Our Case Number: ABP-317560-23

Re: Proposed windfarm development including 13 no. wind turbines in Bunnyconnellan, Co. Mayo and hydrogen plant in Castleconnor, Co. Sligo.
Carrowleagh, Bunnyconnellan, Co. Mayo and Curraun, Castleconnor, Co. Sligo.

Re: Strategic Infrastructure Development under Section 37E of the Planning and Development Act 2000 (As Amended) Proposed Firlough Wind Farm, Carrowleagh Td., Bunnyconnellan, Co. Mayo & Hydrogen Plant, Carraun Td., Castleconnor, Co. Sligo (Ref. No. ABP-307264-20) – Mercury Renewables

Title
Proposed Firlough Wind Farm Constructed Wetland Area Details

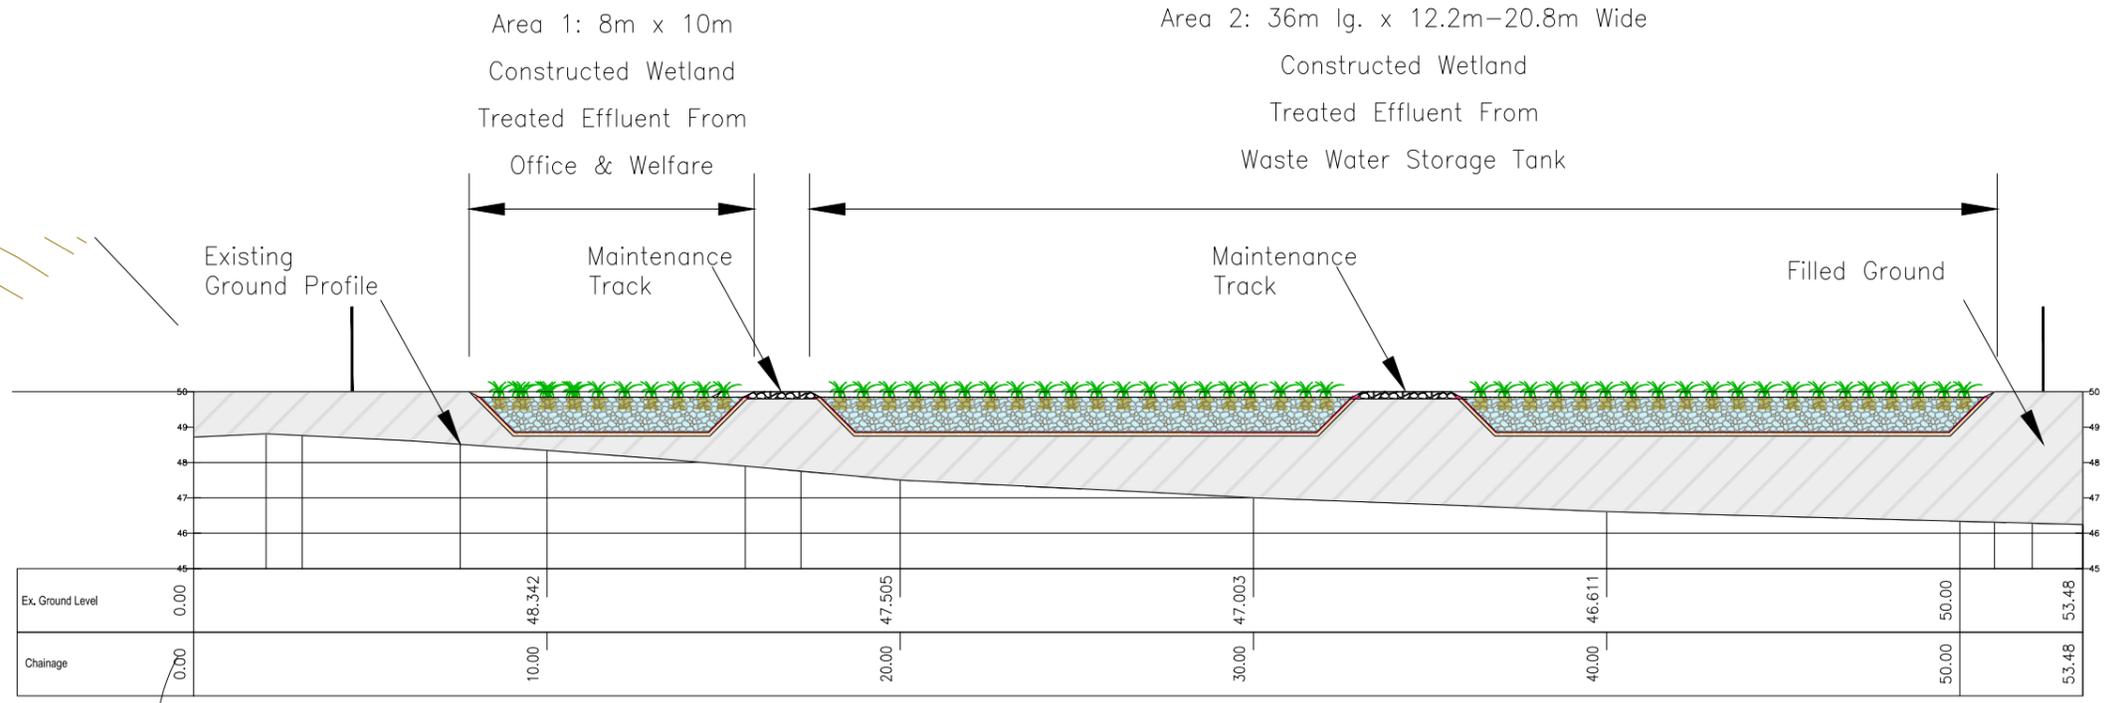
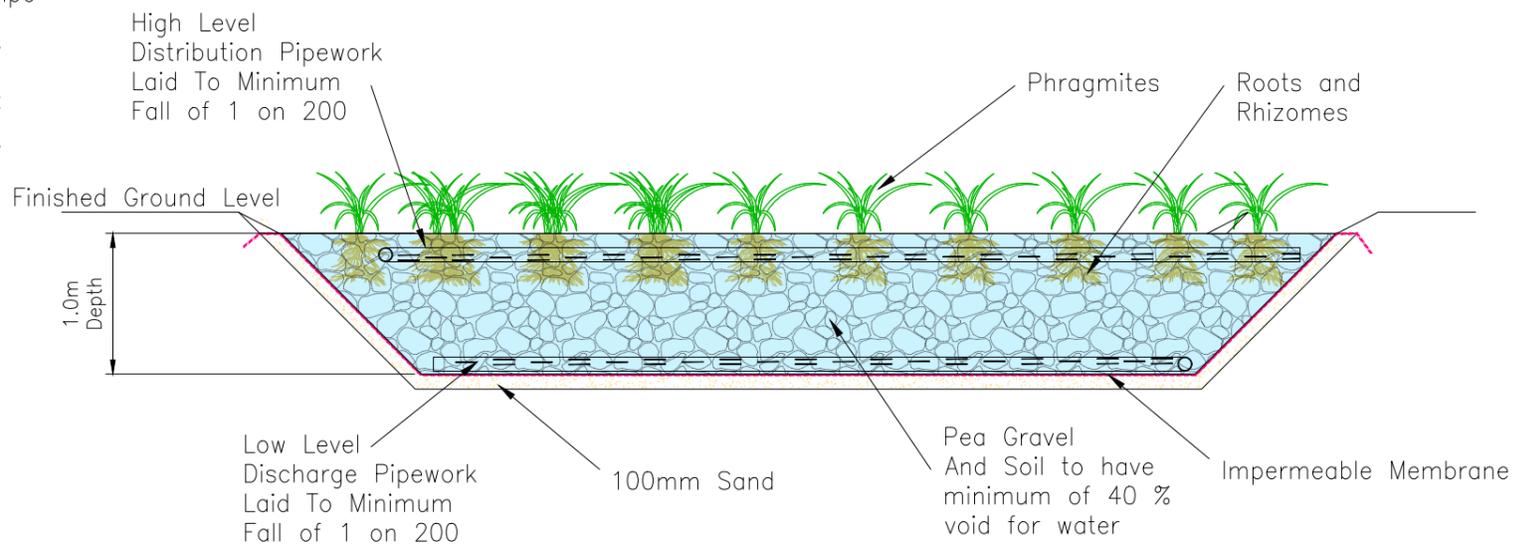
- 9 The constructed wetlands must be engineered to provide adequate treatment and capacity for all wastewater produced on site. All recommendations contained within the Preliminary Discharge & Assimilative Capacity Assessment must be complied with. The capacity of the constructed wetland must provide adequate capacity for extreme rainfall events. An impermeable lining must be used in construction and a discharge sample chamber provided which is accessible to persons authorised under the Water Pollution Act 1977. A maintenance and repair/replacement program for the wastewater treatment plant and constructed wetlands system must be drawn up and a long-term contract put in place for the provision of this service. The installation of septic tank and constructed wetlands must monitored by an engineer and photos of the installation retained.
